TfNSW reference: WST24/00054 | SF2024/037669 | WST23/00079
Your reference: SSD-33964533

SSD-33964533 – Goulburn River Solar Farm – Response to RFI

This attachment relates to TfNSW's response dated 7 May 2024 reference WST24/00054.

DRAWING NUMBER 0305-DRG-01-RD-0201																					
ISSUE STATUS STRATEGIC DESIGN																		SHEET No. 01-RD-0201	ISSUE A

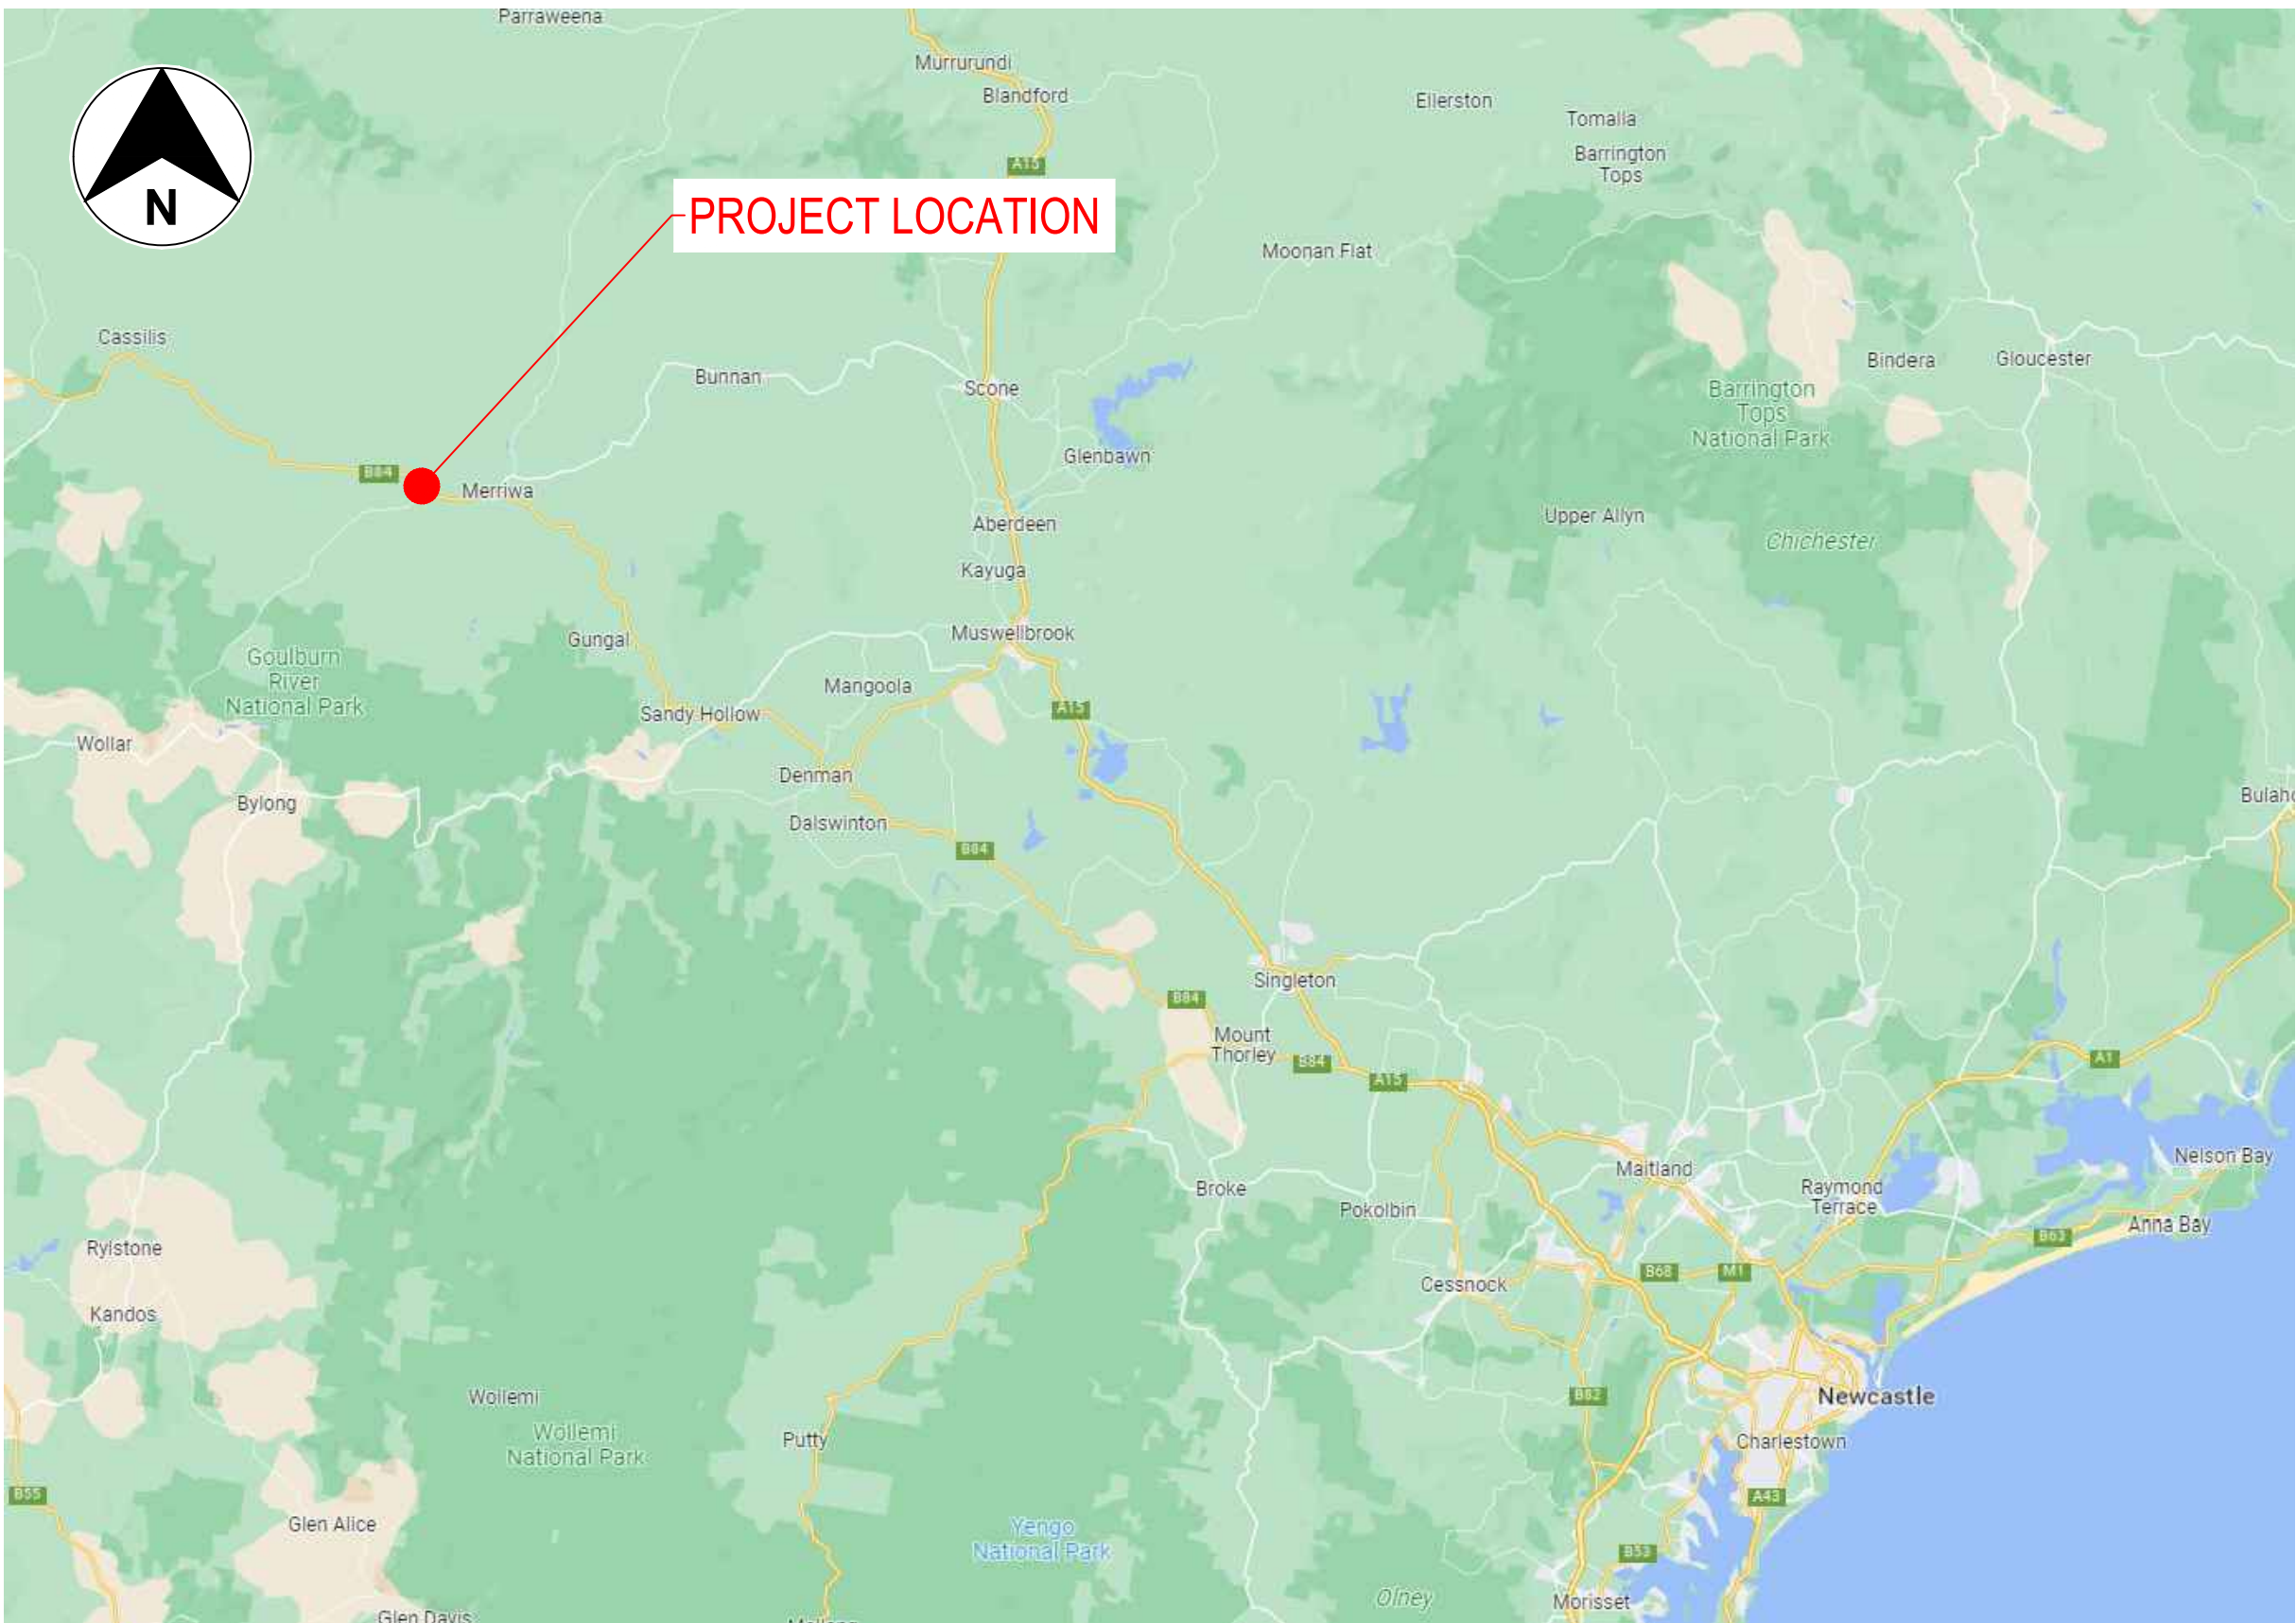
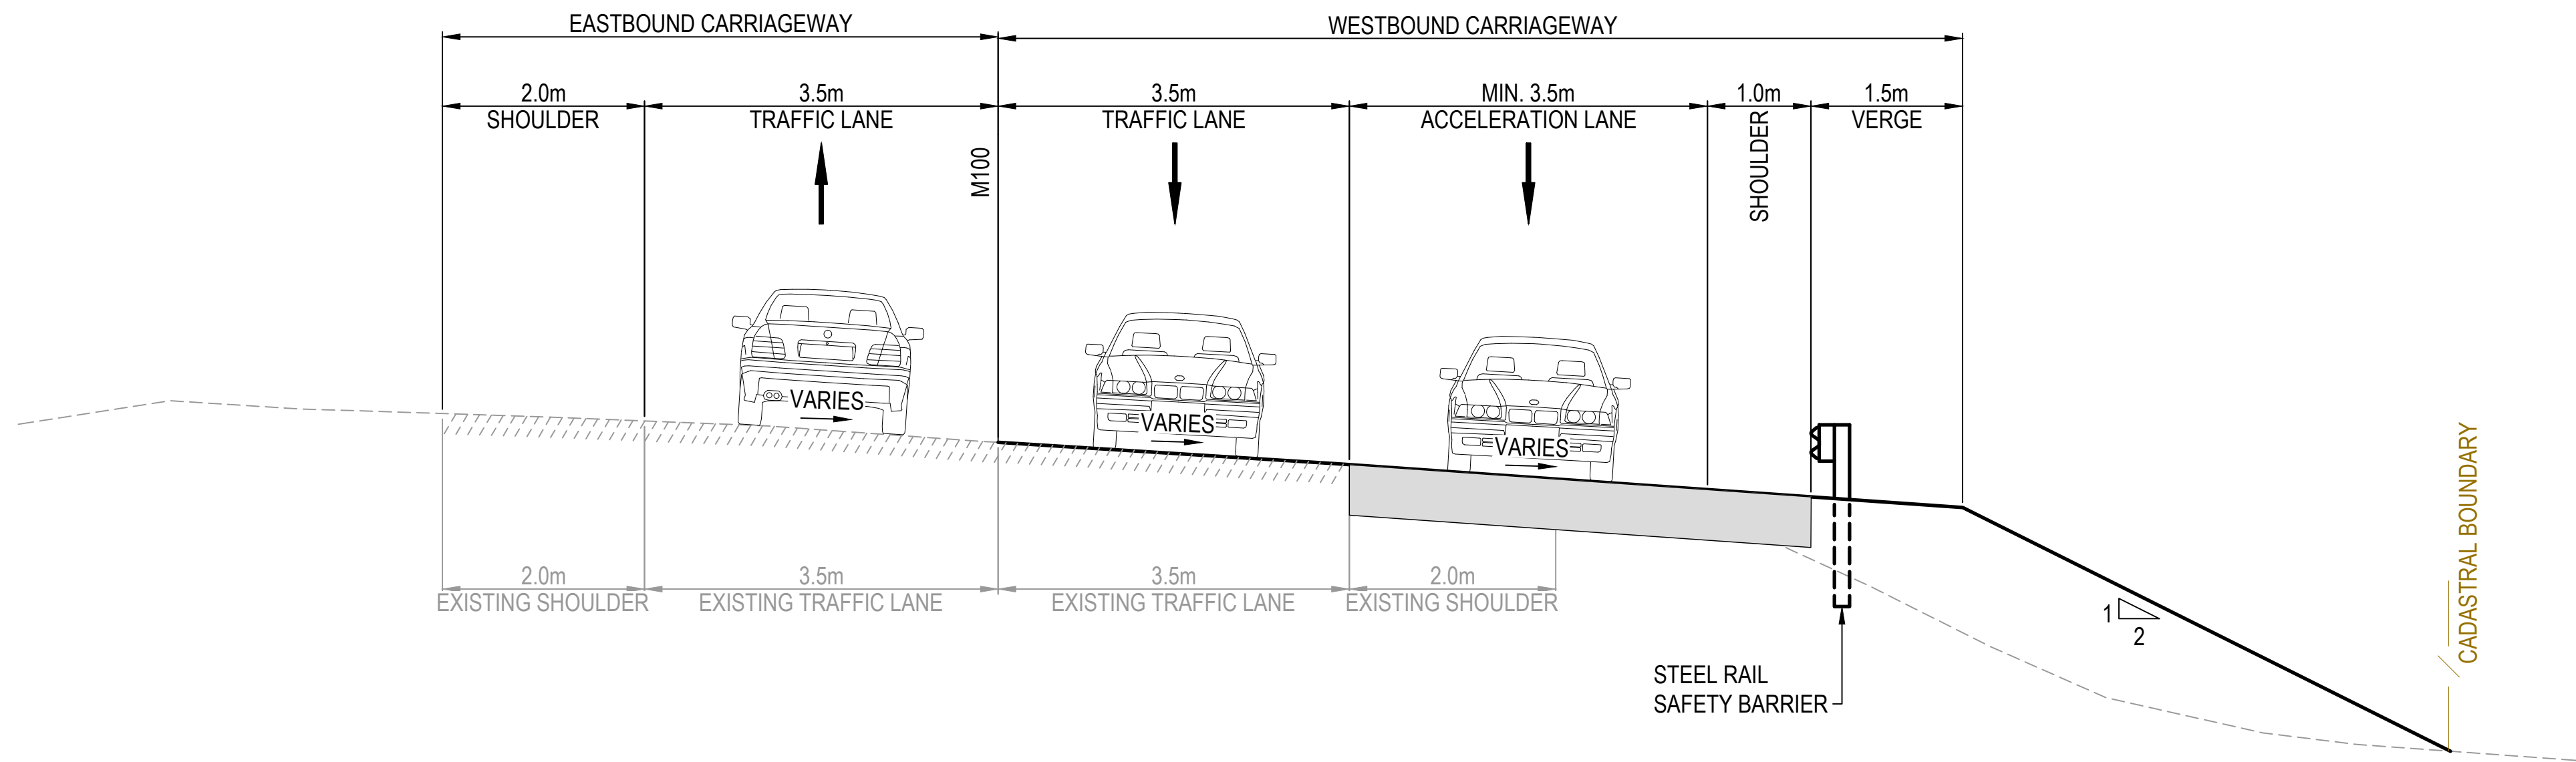
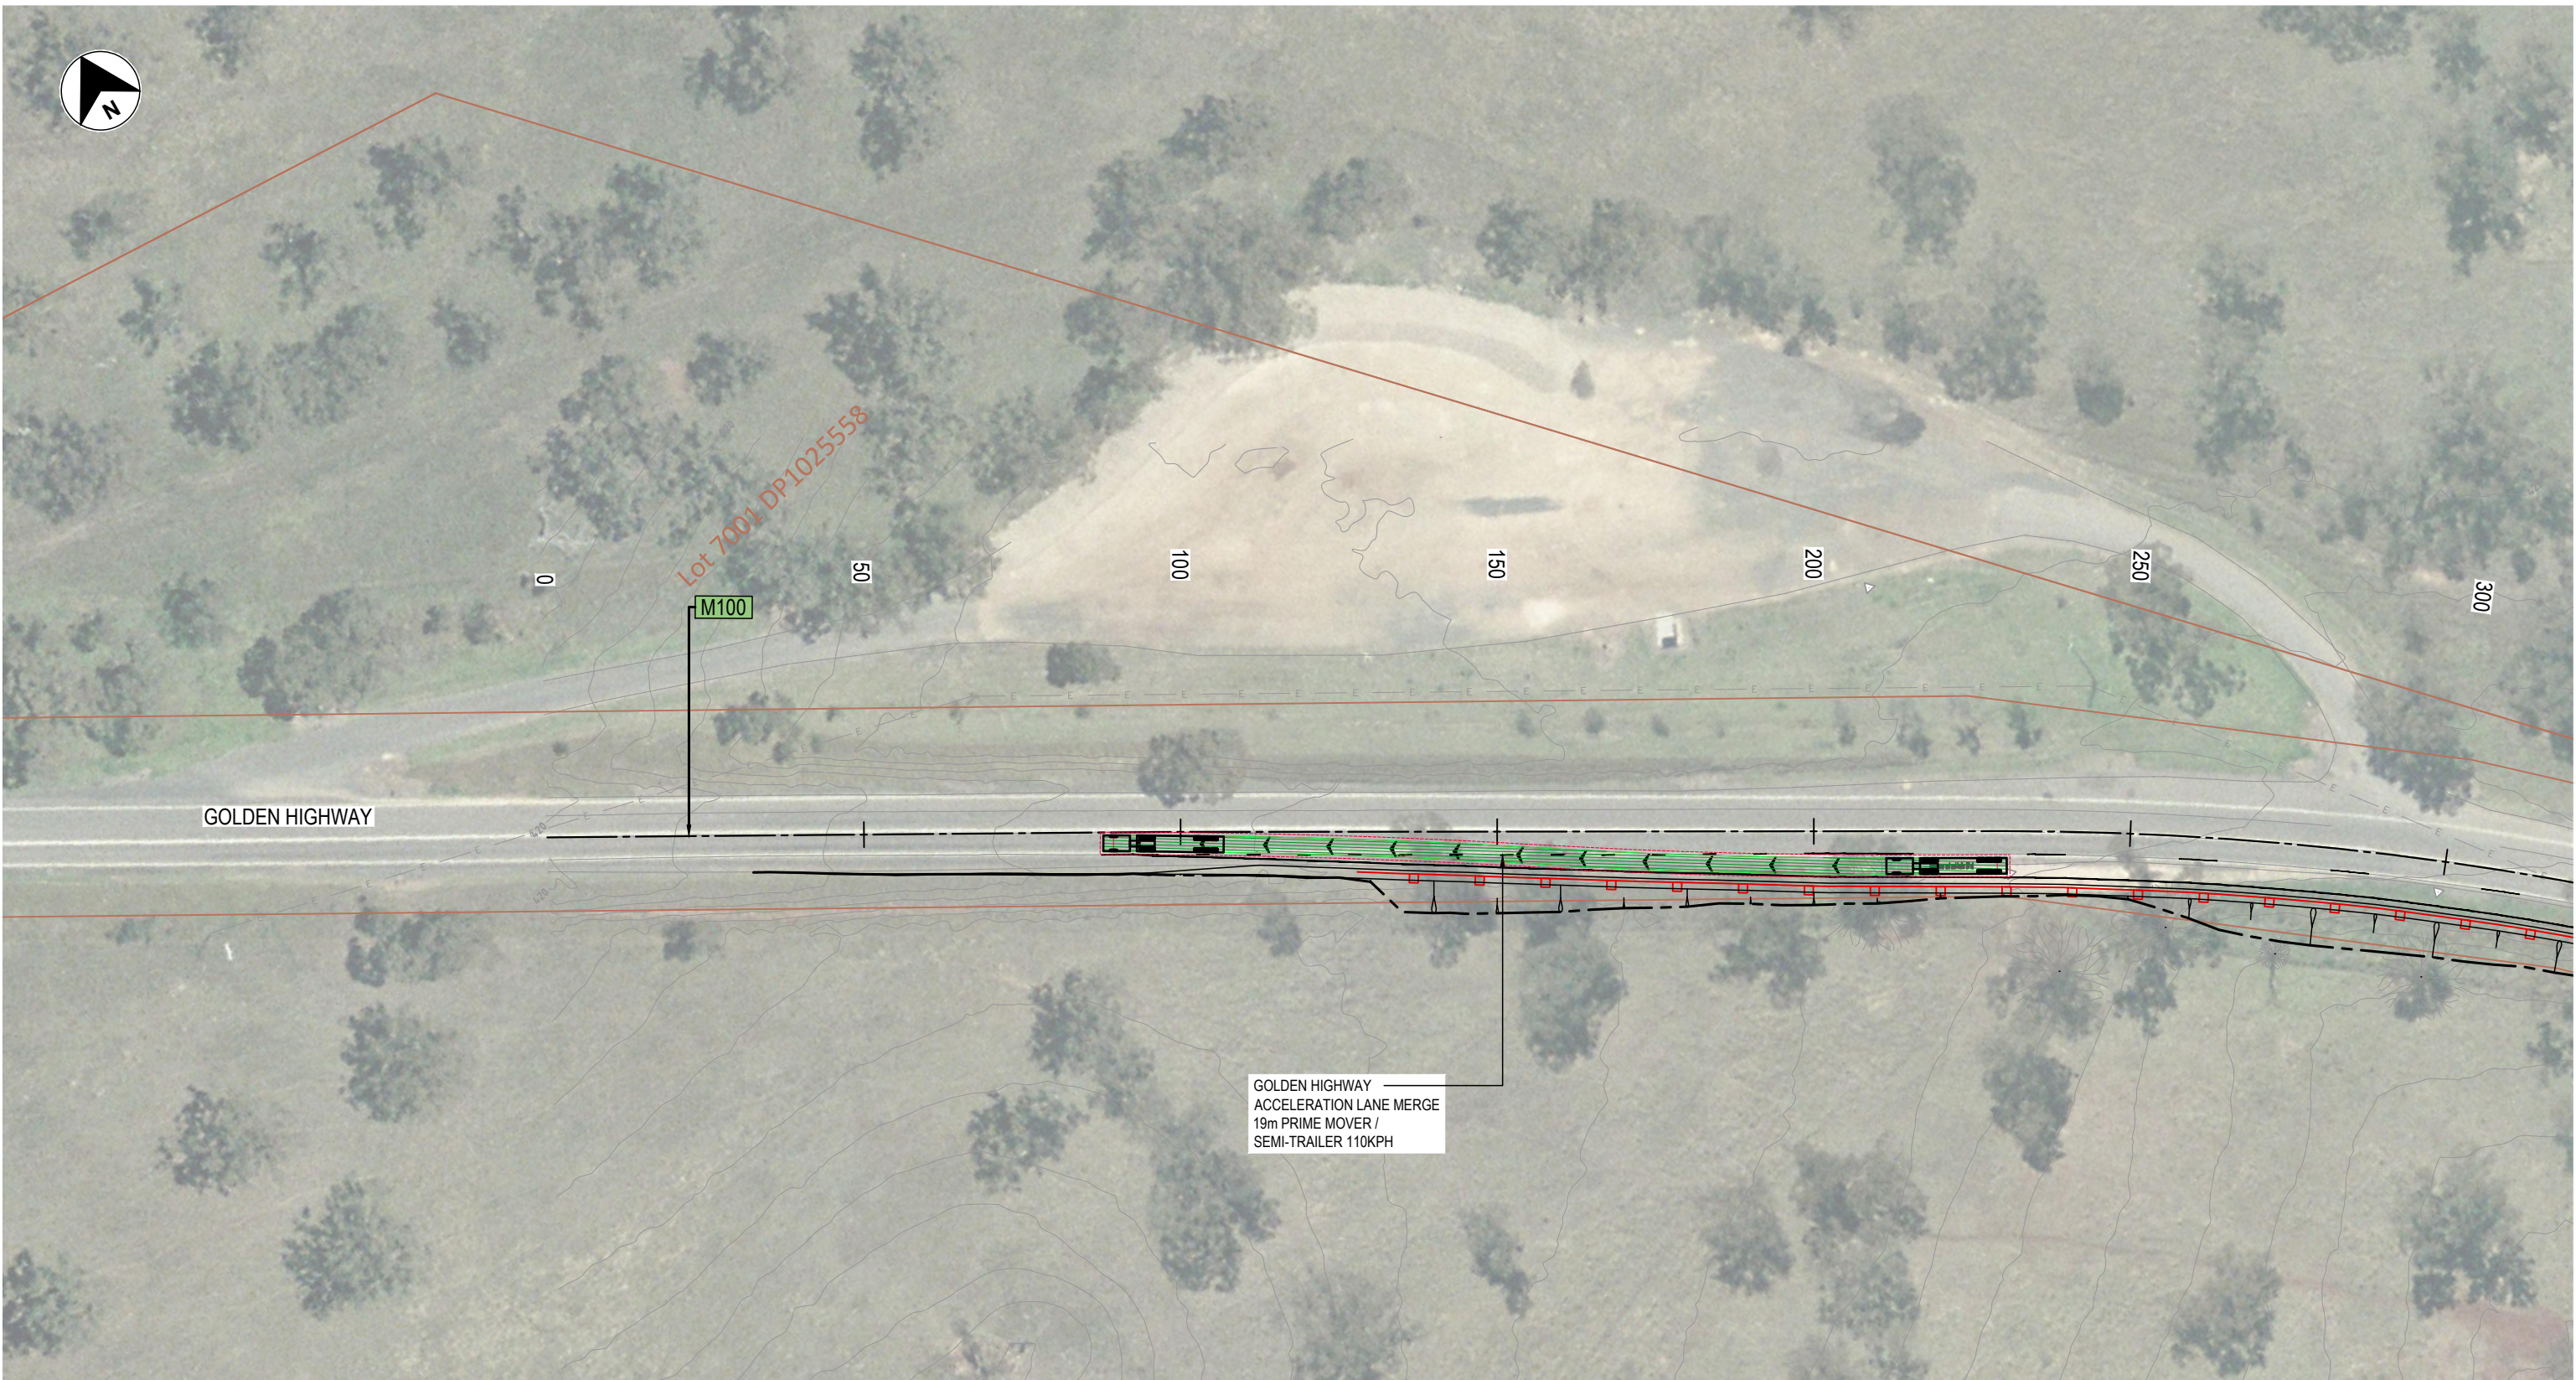
1. The designs submitted (*Goulburn River Solar Farm – Ringwood Road and Golden Highway Intersection Road Upgrade- Strategic Design Rev A 27.10.23 by Turnbull*) to support the left in /left arrangement are generally acceptable. Further information has been provided regarding the existing BAR treatment and show that further works are required to move the existing safety barrier. The final BAR treatment will need to comply with the requirement of Austroads.
